EL PASO COUNTY GRADING AND EROSION CONTROL PLAN CHECKLIST

EPC Project Number: EGP-XX-XXX EGP226

SADDLEHORN RANCH - FILING 5
LEGEND & NOTES

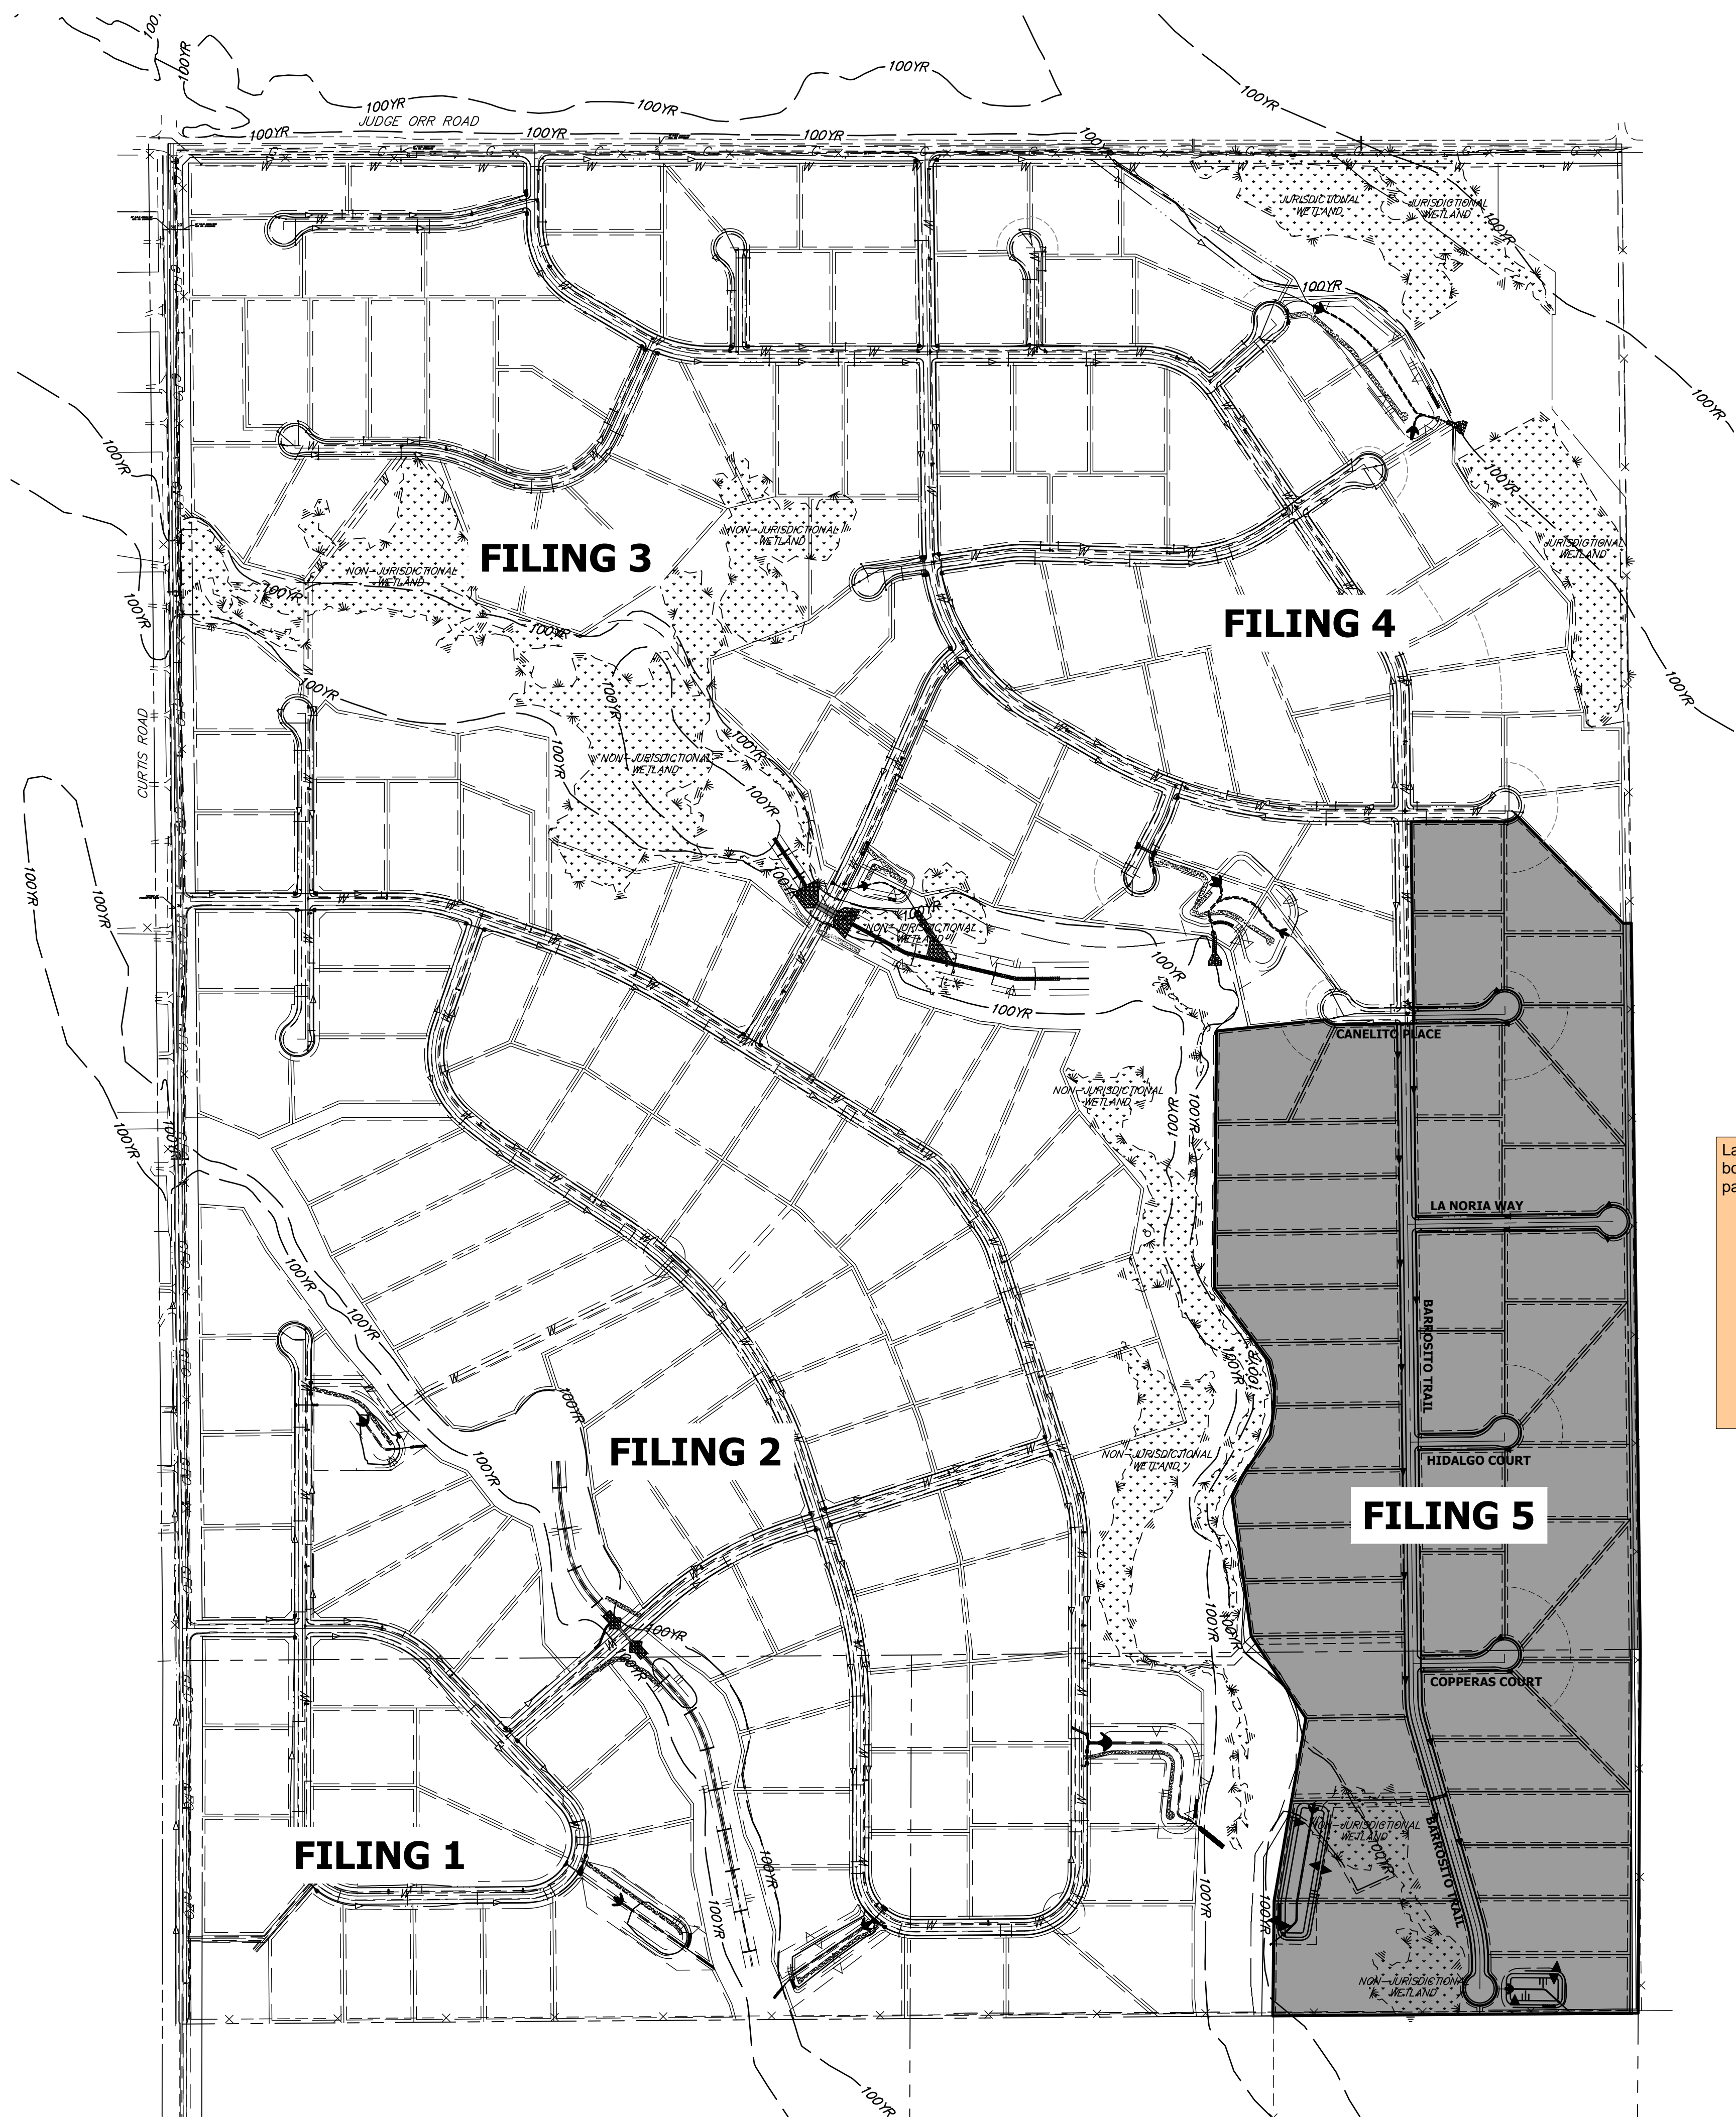
Parcel numbers labeled

1. GRADING AND EROSION CONTROL PLAN (complete form using Y, N, N/A in the "Applicant" column)		
a	Vicinity map	Y ✓
b	Adjacent city/town/jurisdictional boundaries, subdivision names, and property parcel numbers labeled	Y ✗
c	North arrow and acceptable scale (1"=20' to 1"=100')	Y ✓
d	Legend for all symbols used in the plan	Y ✓
e	Existing and proposed property lines. Proposed subdivision boundary for subdivision projects	Y ✓
f	All existing structures	Y ✓
g	All existing utilities	Y ✓
h	Construction site boundaries	Y ✓
i	Existing vegetation (notes are acceptable in cases where there is no notable vegetation, only grasses/weeds, or site has already been stripped)	Y ✓
j	FEMA 100-yr floodplain	Y ✓
k	Existing and proposed water courses including springs, streams, wetlands, detention ponds, stormwater quality structures, roadside ditches, irrigation ditches and other water surfaces. Show maintenance of pre-existing vegetation within 50 feet of a receiving water	Y ✓
